**RE: 9101 Central Ave NW
Erosion And Sediment Control Plan
Engineer's Stamp Date: 2/28/24 (K09E002)**

Based on the information in your submittal received on 2/28/24, the above-referenced ESC Plan can't be approved until the following comments are addressed.

EROSION AND SEDIMENT CONTROL PLAN PHASE II FINAL

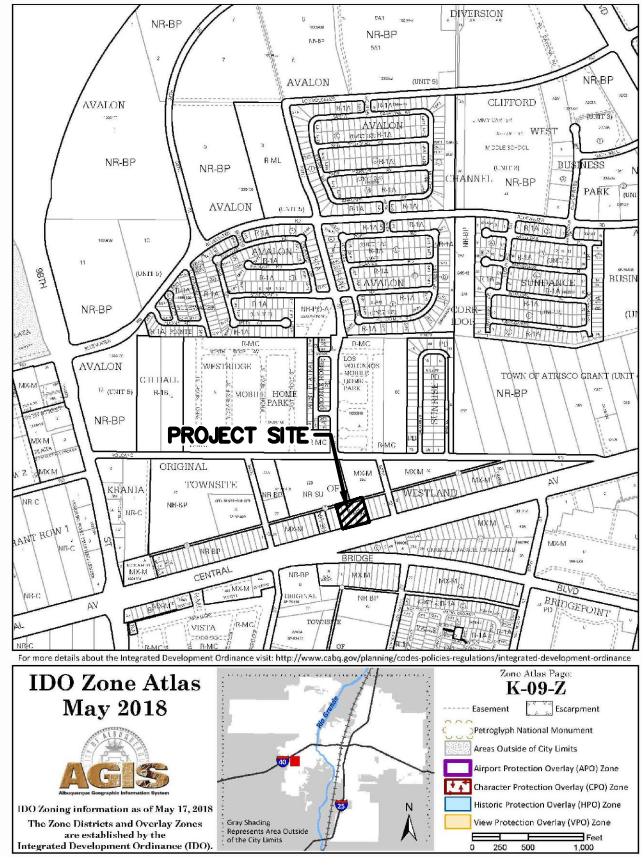
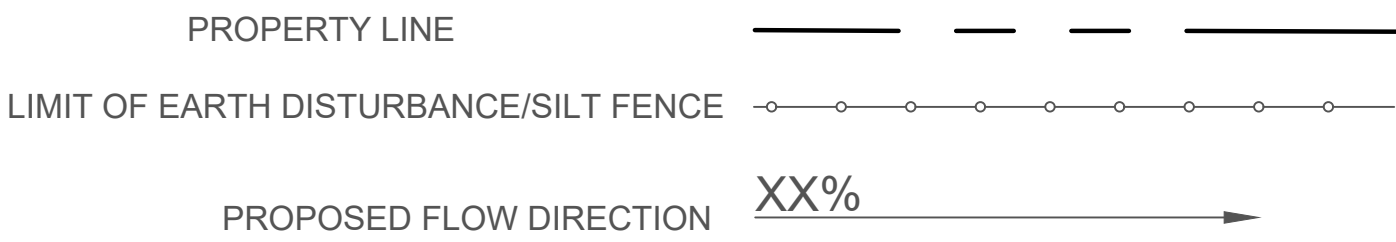
1. The NOI documentation for the property owner is missing. After you submit it to the EPA, you must provide the property owner's e-NOI.
2. To get a fugitive dust permit, a silt fence will be required around the entire perimeter of the site for air quality. Silt Fence should replace the Mulch Socks shown on the plan to make it easier to keep the SWPPP map up-to-date as required by the EPA's Construction General Permit Part 7.2 (CGP 7.2).

3. The SWPPP must include site-specific interim and permanent stabilization specifications per CGP 9.6.1.c.i. The Landscape Plan can satisfy this requirement and should be submitted separately from the ESC Plan with the application to the Stormwater Quality Section of the Planning Department. It should also be included in the SWPPP. Provide specifications on the ESC Plan for any disturbed areas not covered by the Landscape Plan sheets.

4. The infrastructure in the Central Ave right-of-way required by Transportation (attached) doesn't appear on the G&D Plan or the ESC Plan. If the infrastructure is required in Central Ave., then a revised G&D Plan and ESC Plan and additional fees will be required prior to the SWQ Section approval for Work Order. If the right of way is disturbed for any purpose during this project then the area must be identified within the limits of land disturbing activities on the ESC Plan, controls will have to be shown on the plan for that area, stabilization will have to be specified for that area, and the controls and stabilization must be constructed according to the requirements of the CGP.
